Site Development Plan_v1.pdf Markup Summary

SHEET INDEX:
COVER SHEET P1
SITE PLAN MAP P2

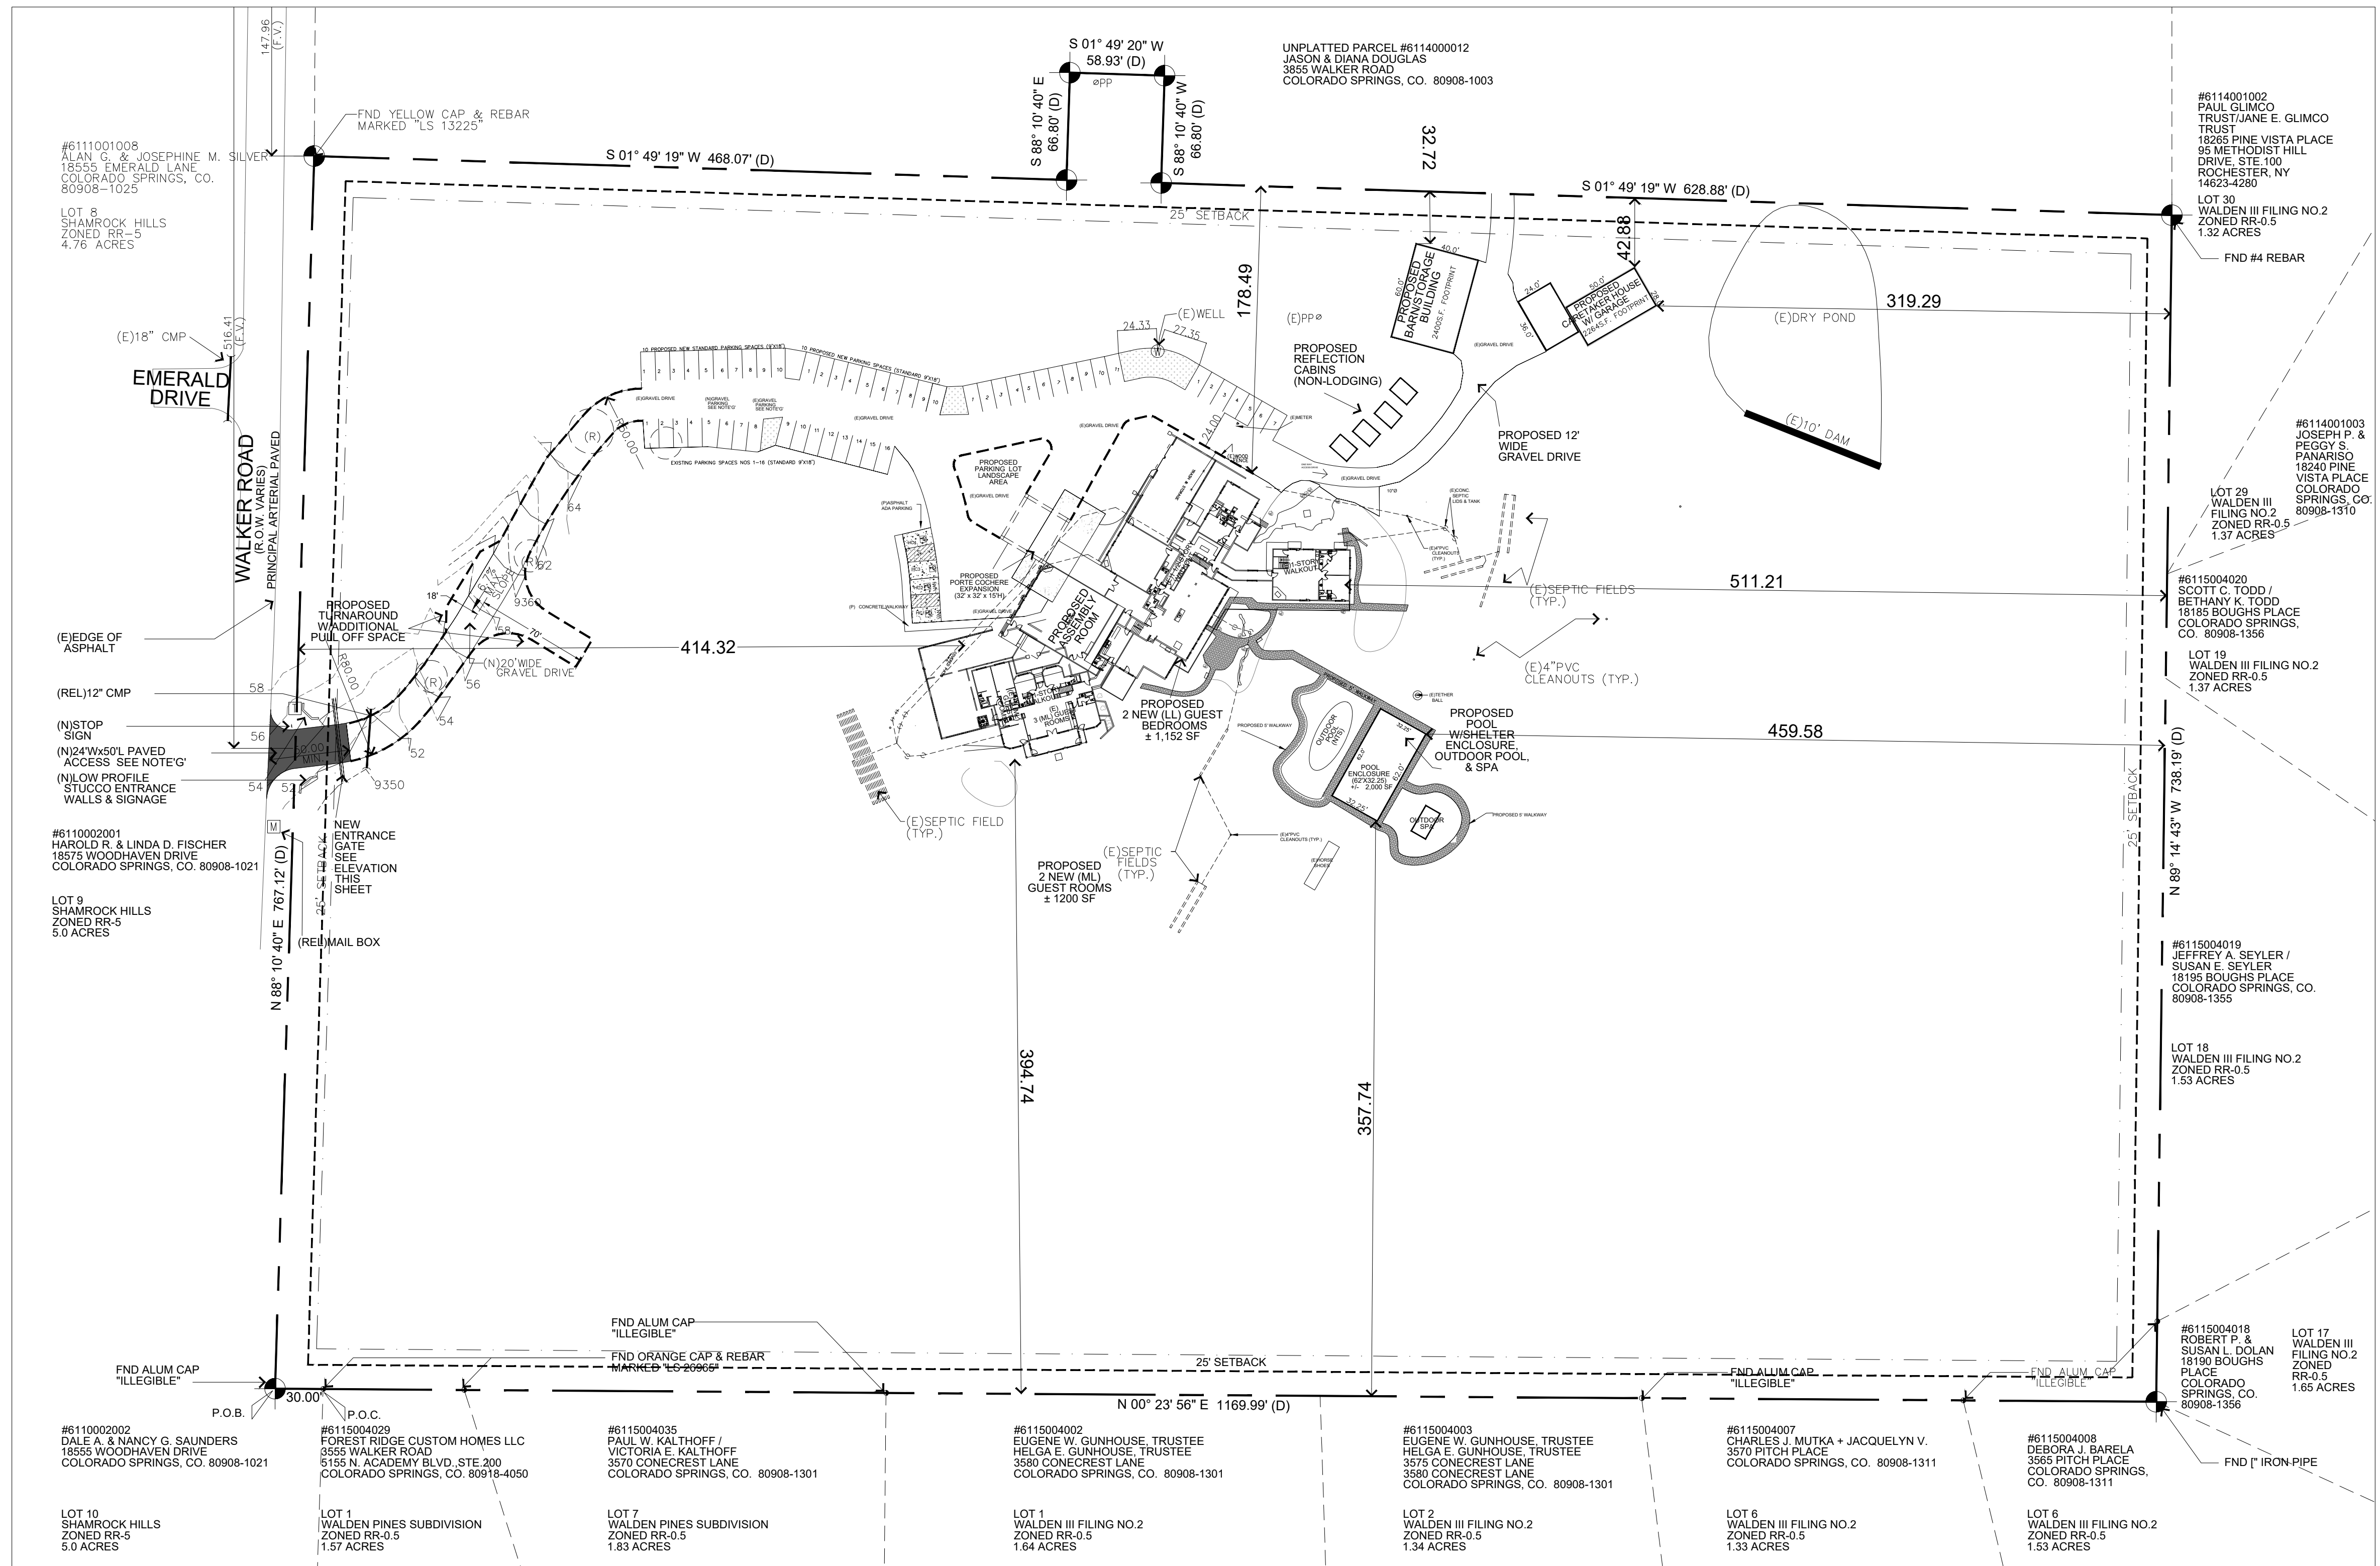
If the adjoining property is owned by the
Indians and the property is to be used by
and for employees, we will want to see a joint
lease agreement.

Please provide a legend.
